Our Ref: MCE/2205771-DRAFT

Thank you for your pre-application comments following the second meeting and a review of the documents for the proposed development at Ford Airfield. We are continuing to work on the proposals and taking on board your comments.

ARUN DISTRICT COUNCIL F/16/24/RES

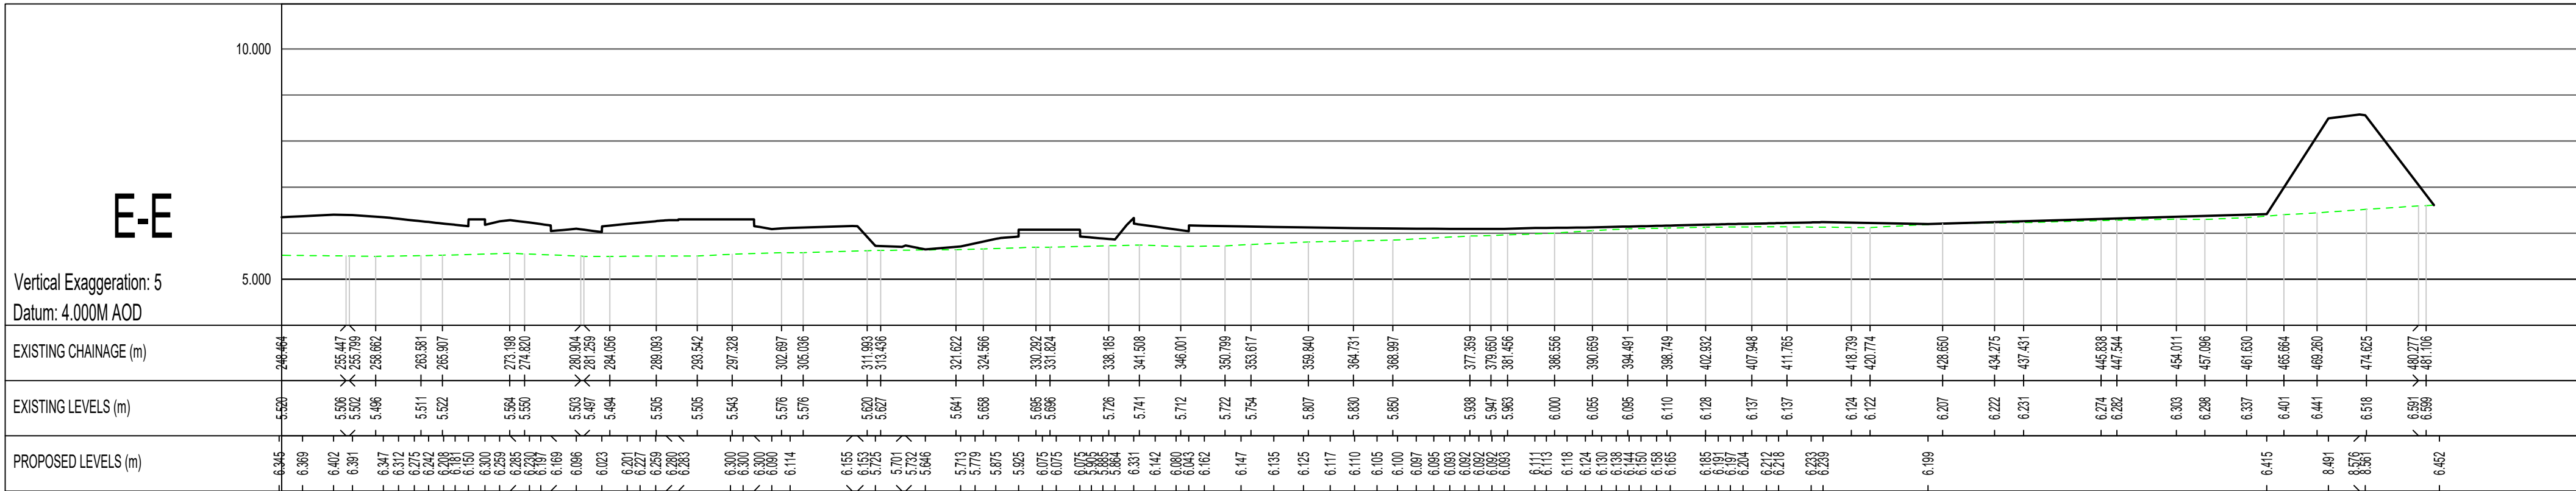
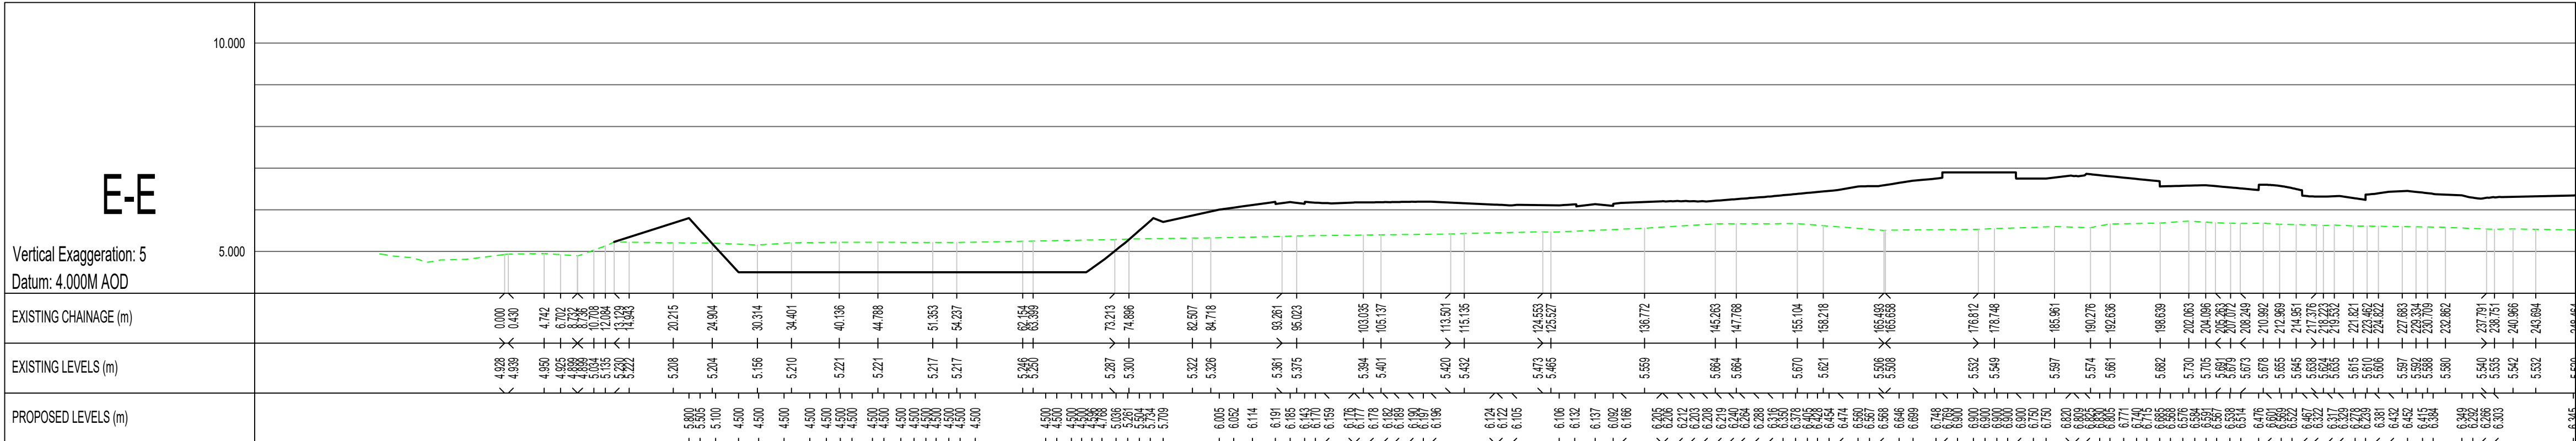
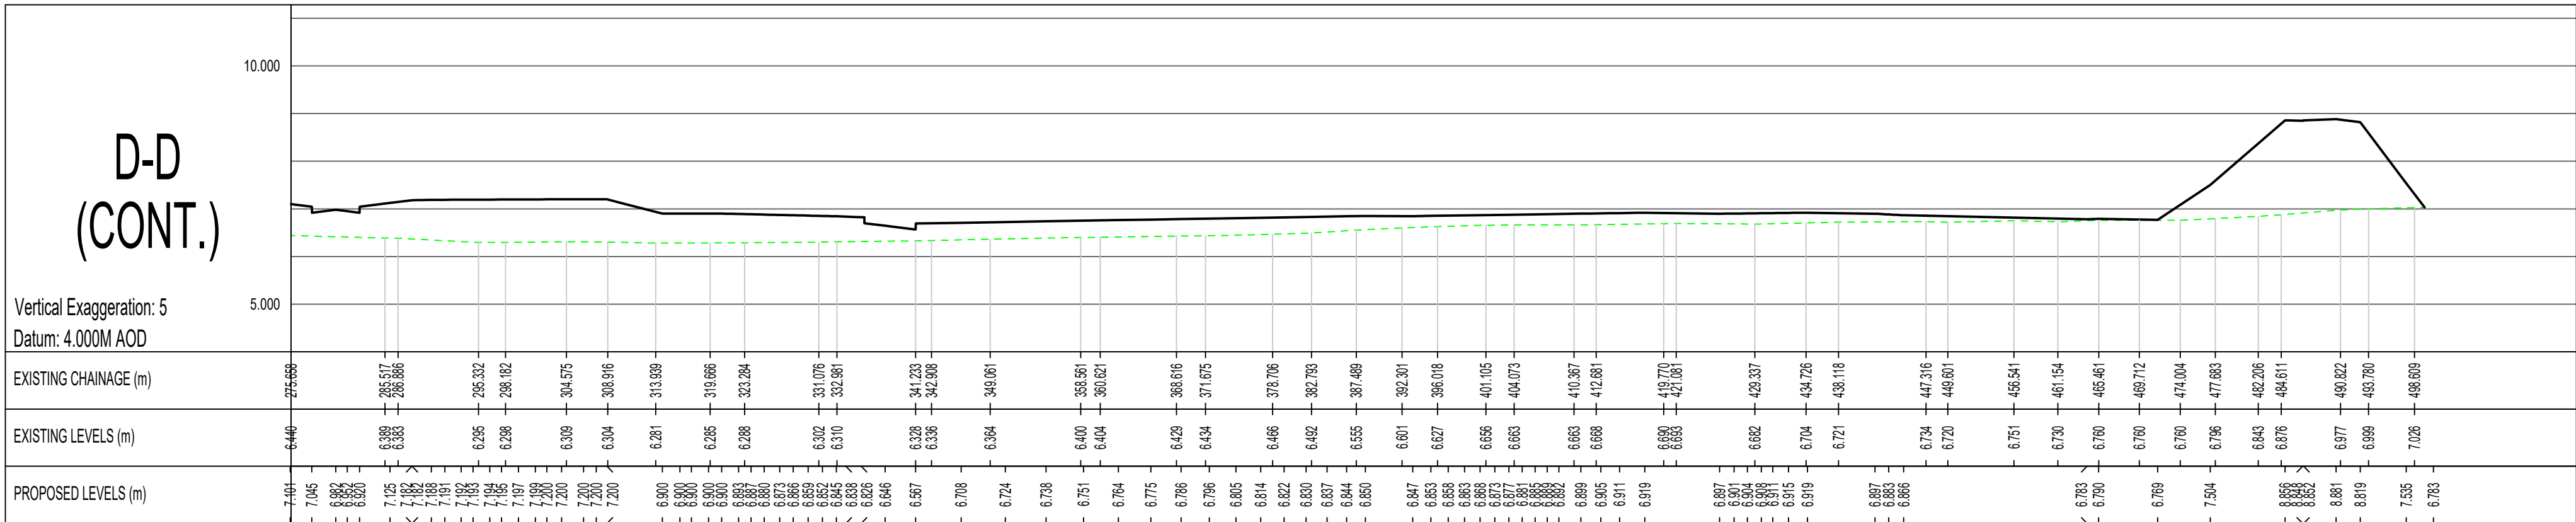
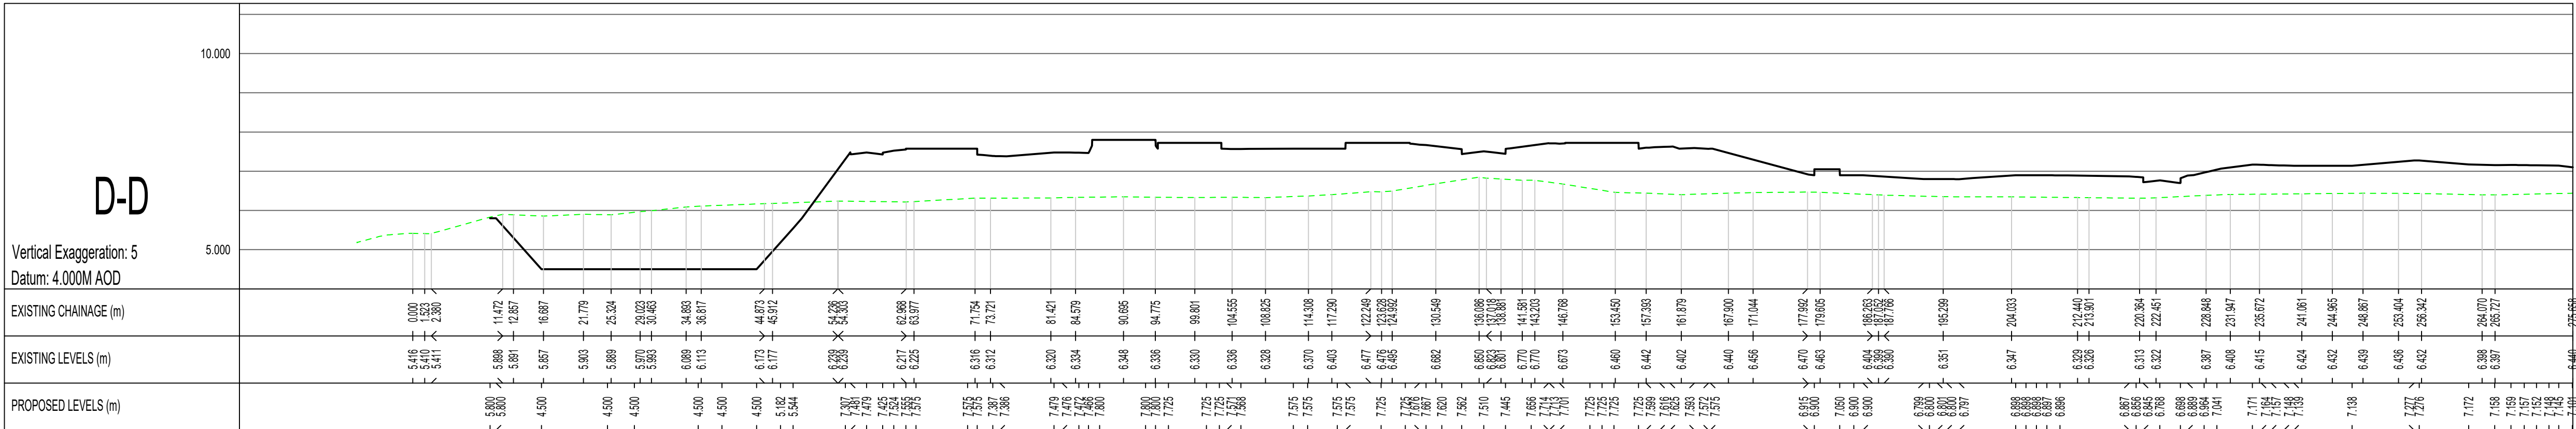
13. Cross sections and long sections of the network and structures such as basins and swales will need to be submitted.

Noted. Cross sections & long sections of the basins and swales will be provided as part of the planning submission.

SHEET 2

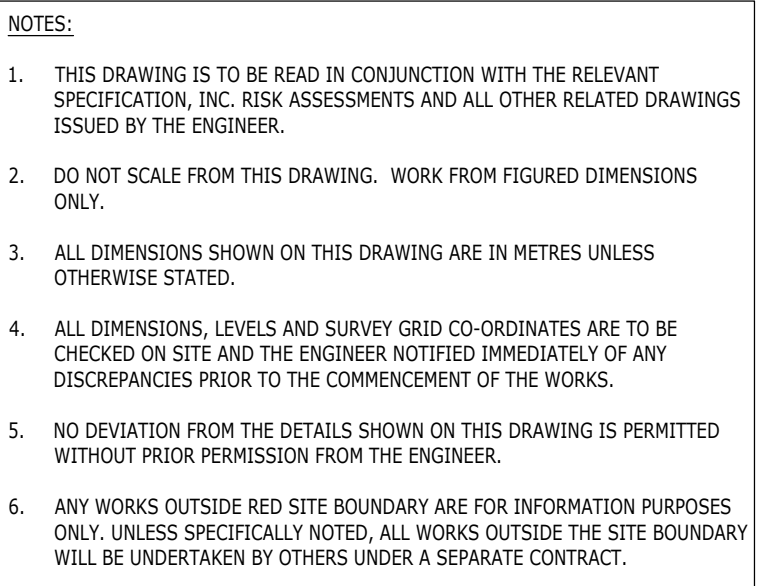
12. Urban creep-it is unclear whether 10% urban creep has been included in the volume of SuDS storage required.

10% Urban creep has been included to the impermeable areas, please refer to the table on the Sitewide SuDS sketch.
